From: Daun Johnson on behalf of Planning.Responses
Sent: 15 February 2018 09:52
To: Planning Scanning
Subject: FW: WA/84/17/PL Fairmeads ' Farm '.

WA/84/17/PL - Fairmeads 'Farm'.

The Block Plan dated 27/1/18 RA671/500/Rev 1 published on 5/2/18 further perpetuates the misrepresentation made previously that there is/was a "paddock" in the location claimed by the dotted lines by stating " former paddock fencing shown dotted now removed ".

**SITE LOCATION PLAN
AREA 16 HA
SCALE 1:2500 on A4
CENTRE COORDINATES: 499314, 105496**

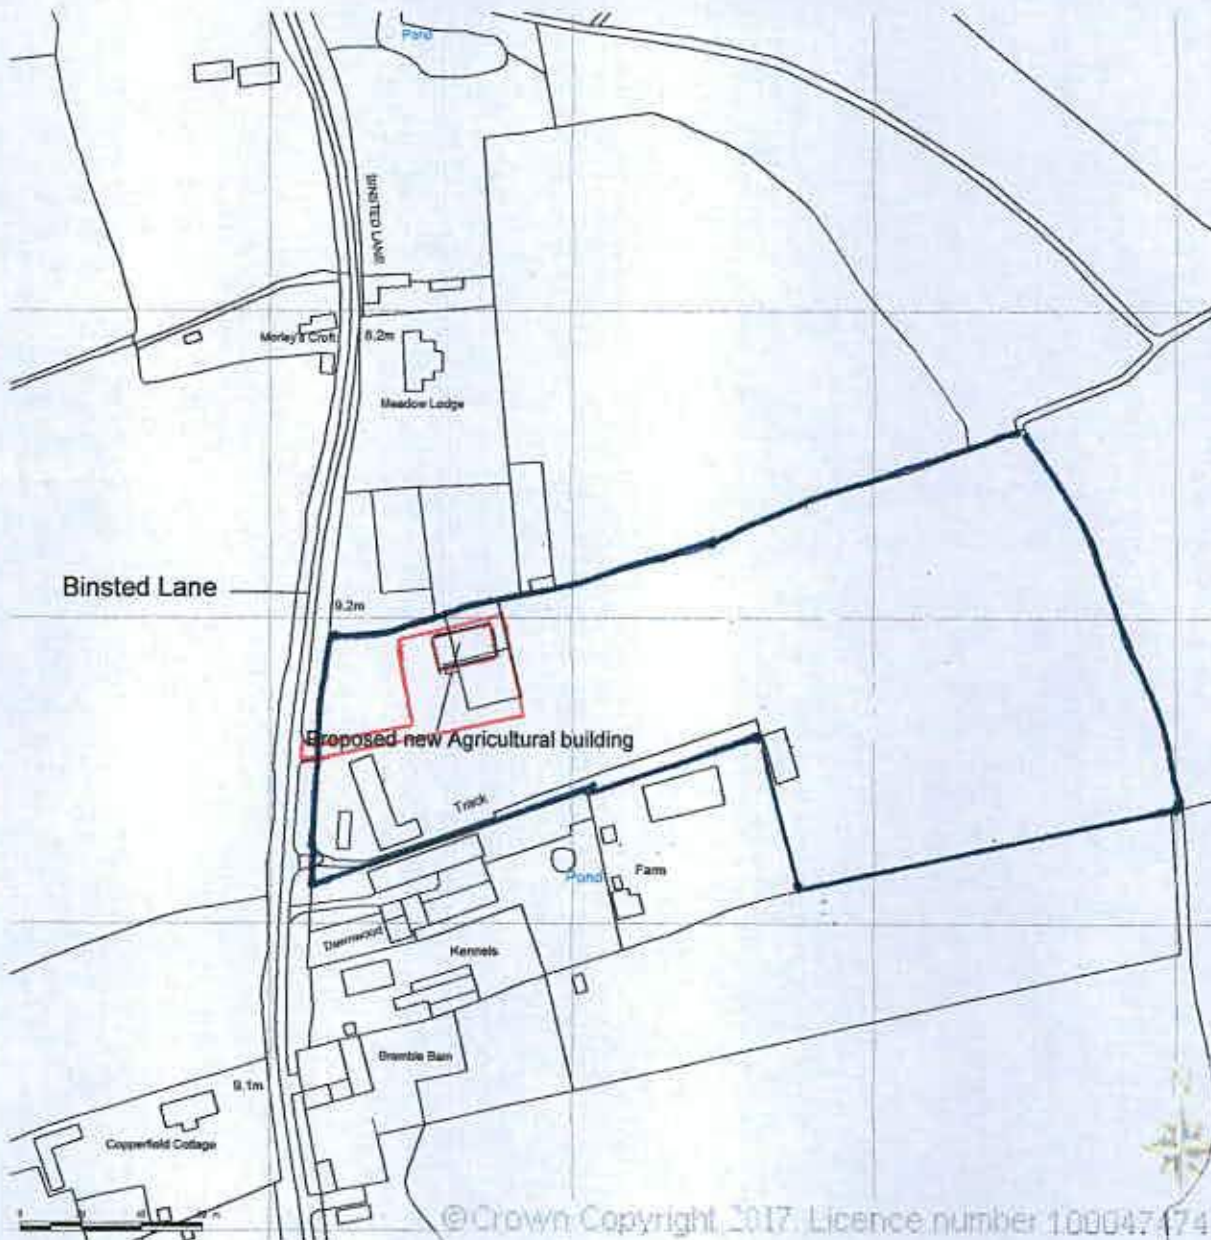
1. One of the Design and Access statements submitted in support of the application is headed "16 HA". Is this intended to mislead the reader to believe the site is 16 Hectares?
2. Para 18 of the application states that the non residential floor space of the proposed building will be 293.5 m2. The plans of the proposed building show a floor space of 190m2.

Drag No RA/671/500 BLOCK PLAN rev 1

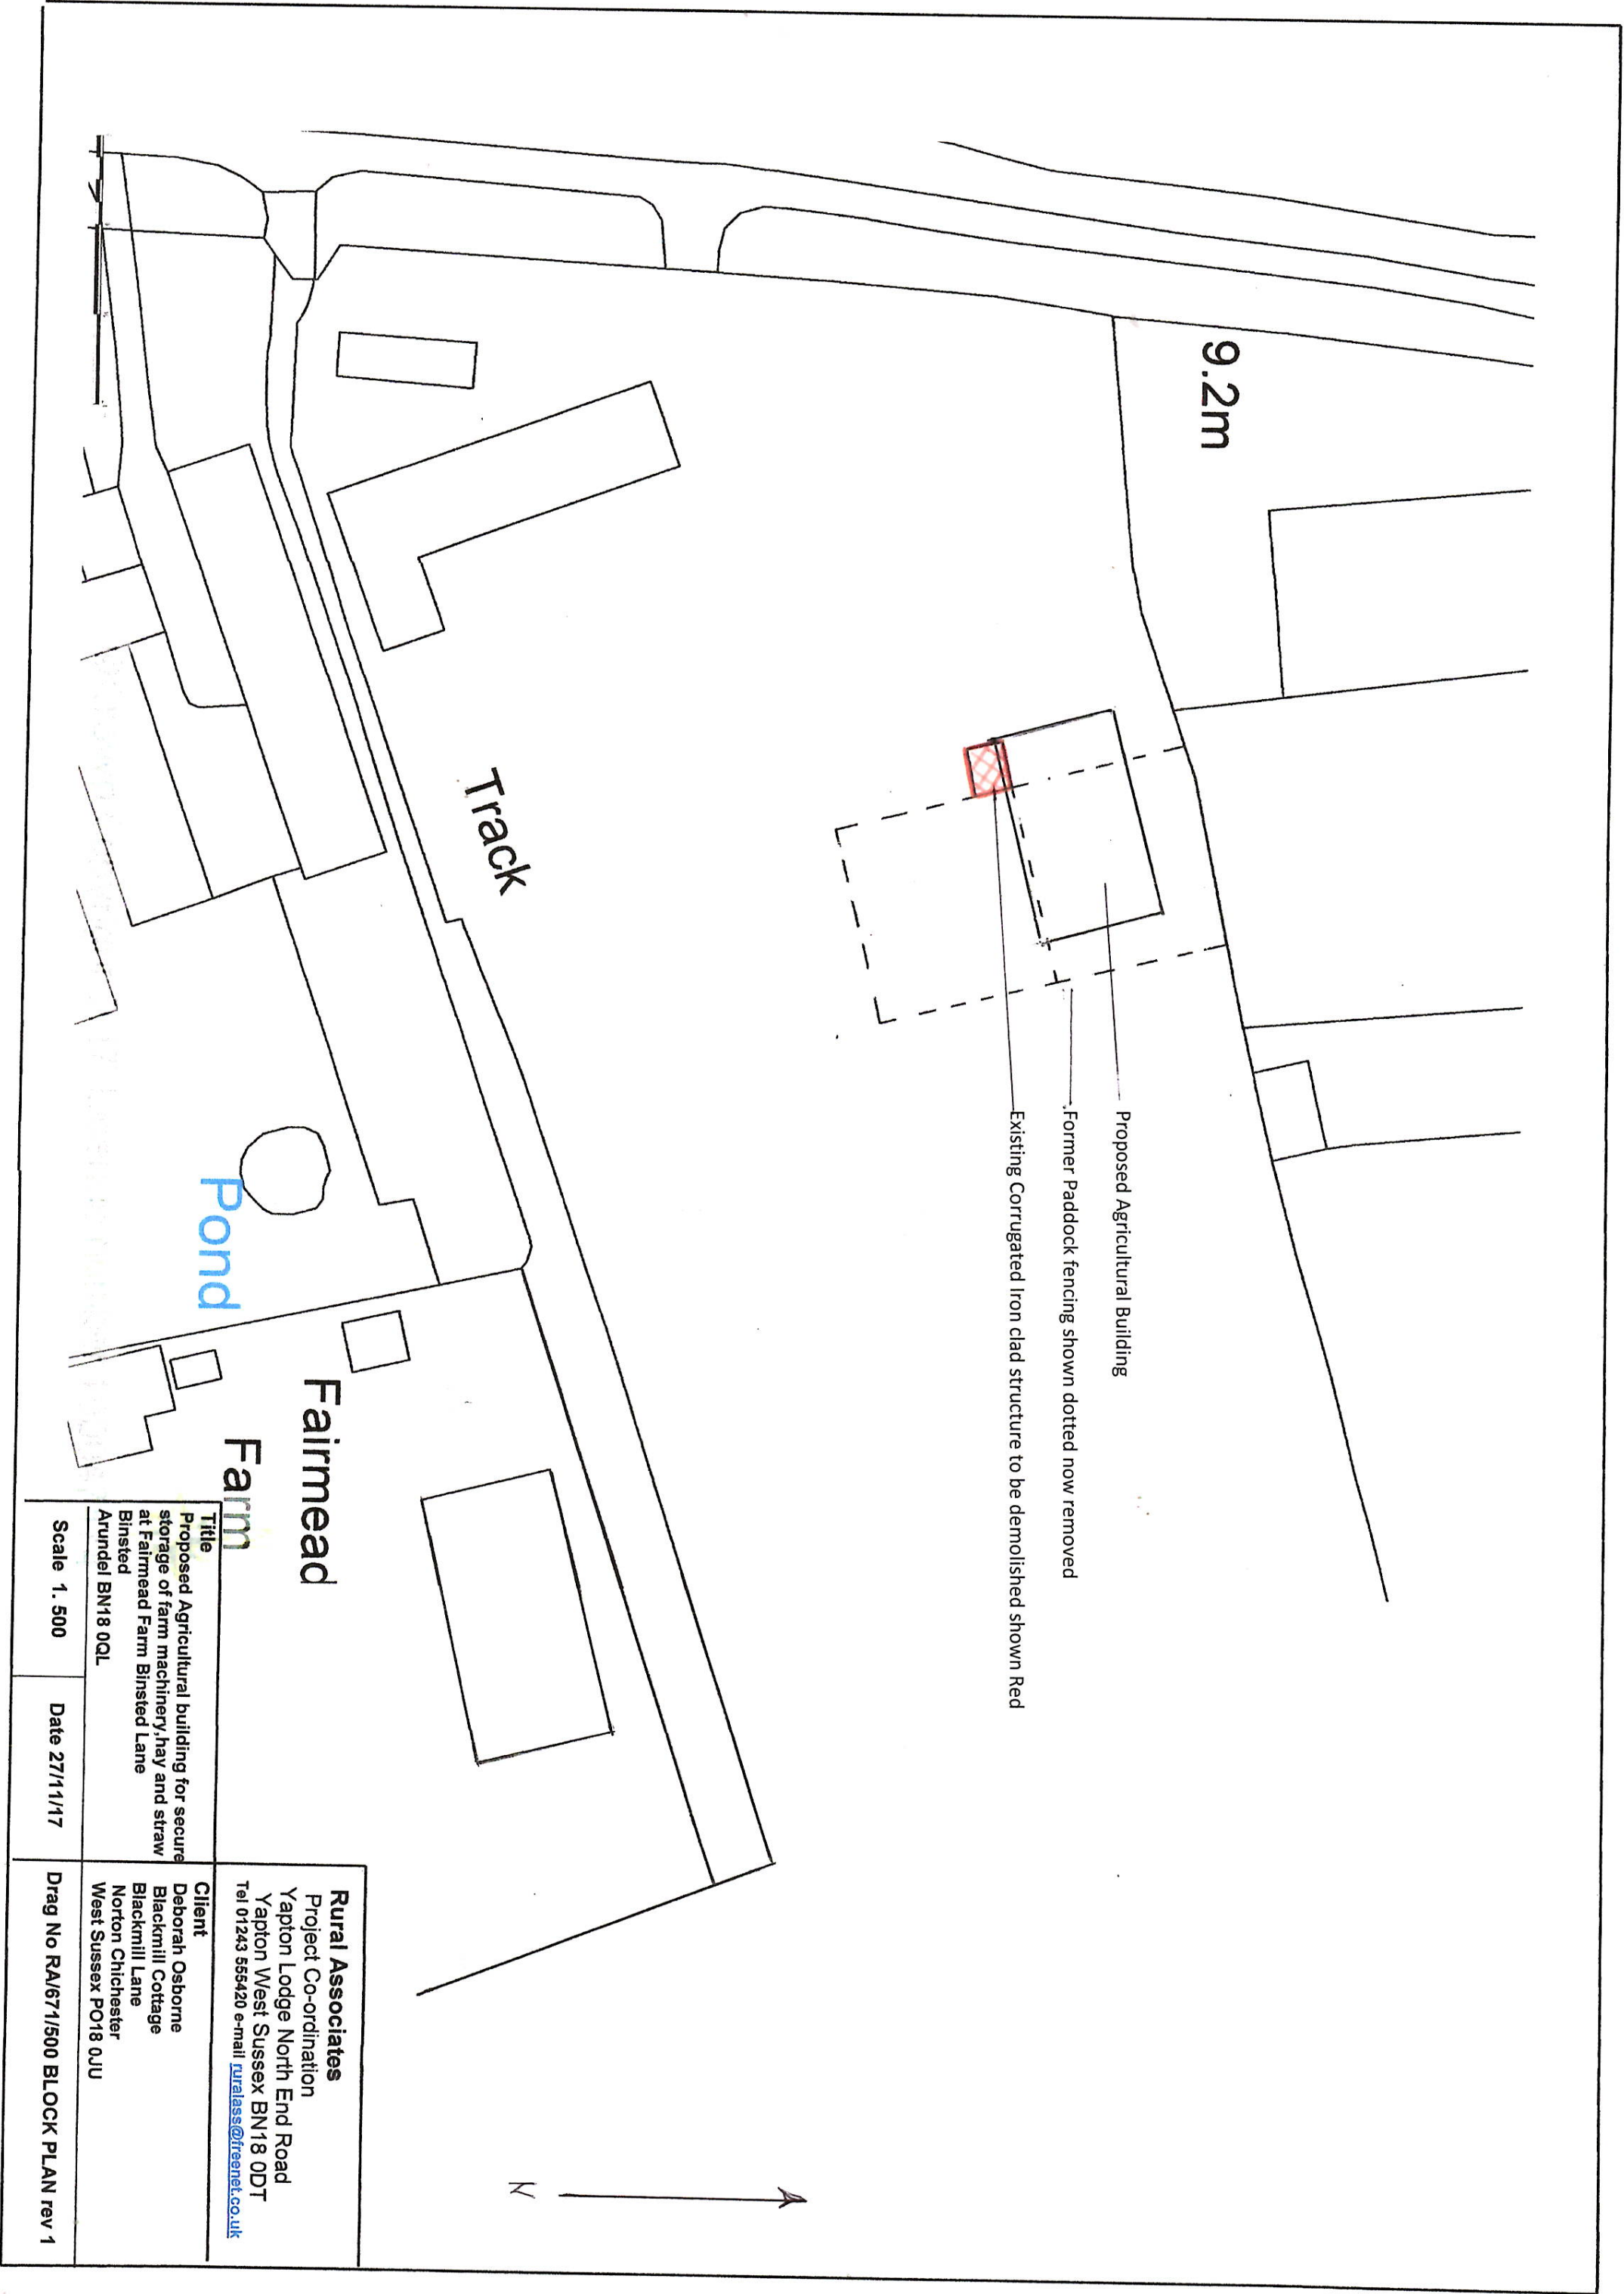
I have lived in Binsted in proximity to the site since 1994 and since that date there has never been any "paddock" as the Applicant is trying to suggest. If there is any evidence of any "structure" existing prior to that date it would be helpful if it could be produced. This historical fact has already been confirmed by Darren Mills.
